141070

Brookfield Multiplex
135 King Street
Sydney NSW 2000

Heritage Building South Eastern Zone

Wall Stability Works Associated with Recently Uncovered Site Conditions

Heritage Building - Level 5

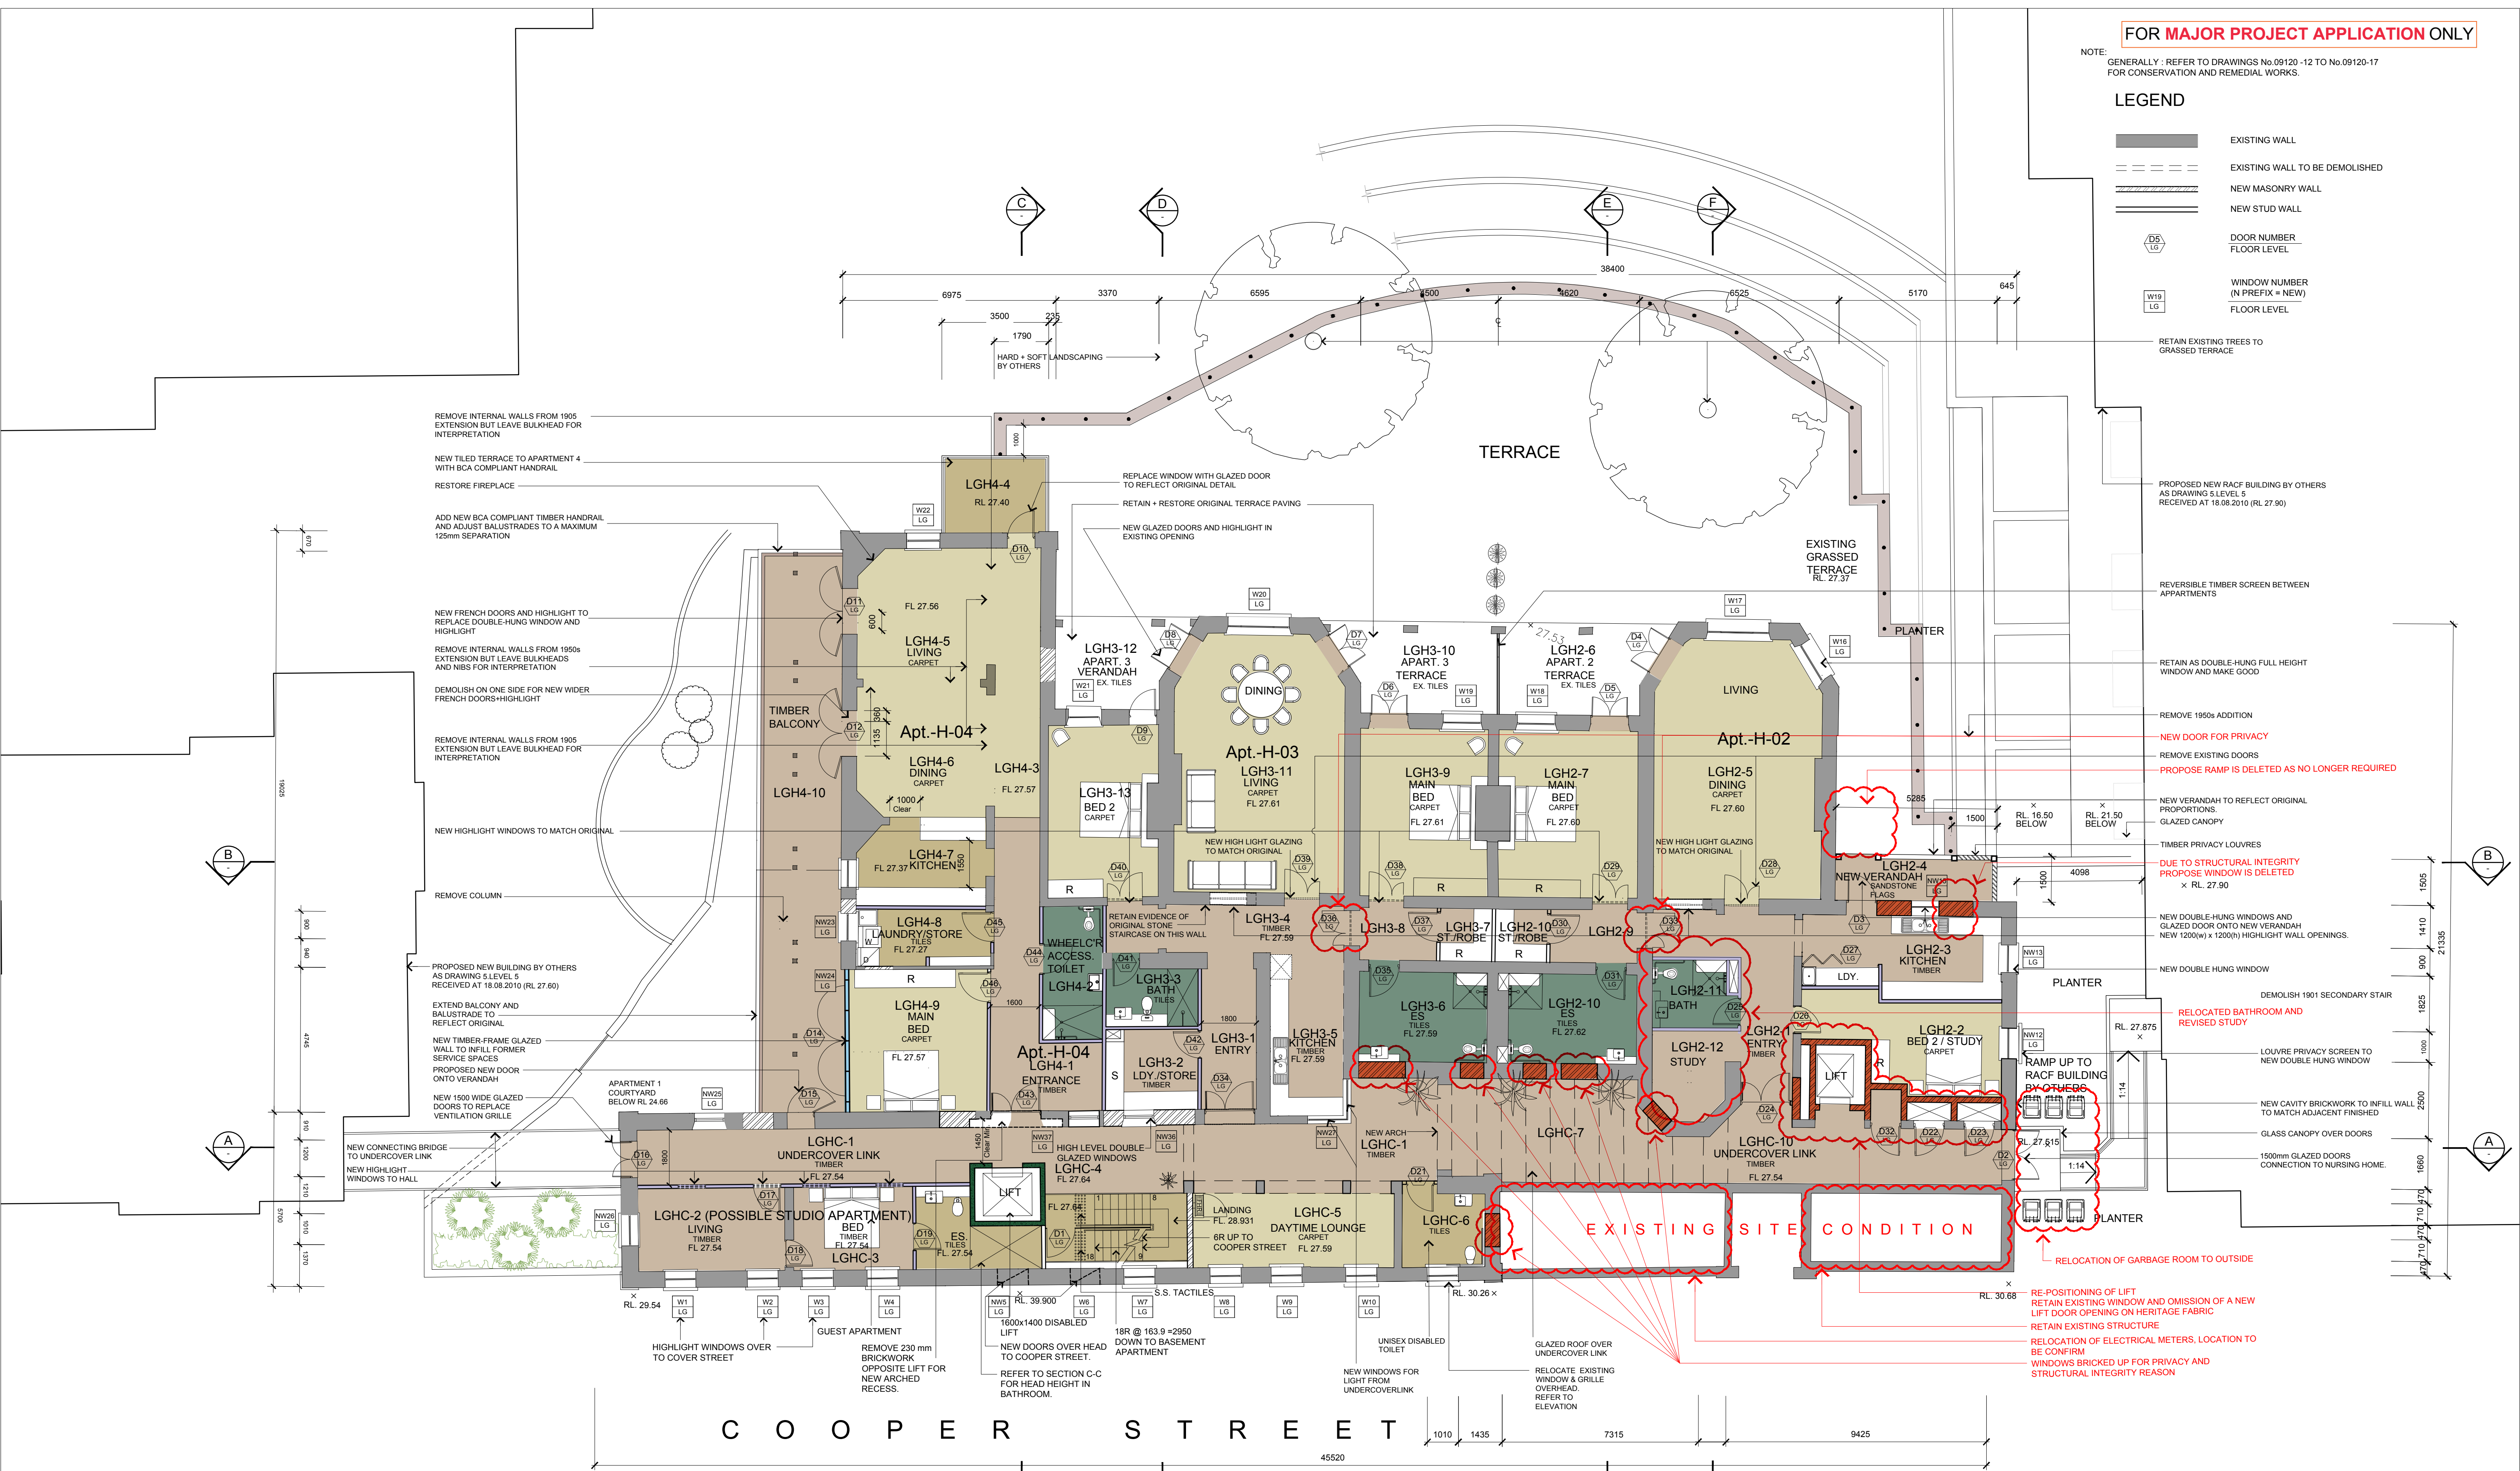
Recent site investigations have confirmed the existing masonry walls as per the attached markup are founded at levels substantially higher than level 5. Some walls were found to have no footing and be sitting directly on the loose sands.

Due to the walls being founded at levels higher than expected, the current approved architectural design levels for the finished floor adjacent these walls would undermine the existing foundations. Therefore underpinning is required to ensure the structural integrity of the existing walls are maintained.

Various options of micro piling, conventional underpinning, and ground improvement methods have been investigated, and the most practical, safe, and least invasive method to underpin these walls down to level 5 is with the ground improvement method of jetgrouting.

This will result in the existing loose sands under and behind the walls being transformed into a low strength concrete like structure that will be able to protect and support the existing structure when the proposed works are carried out.
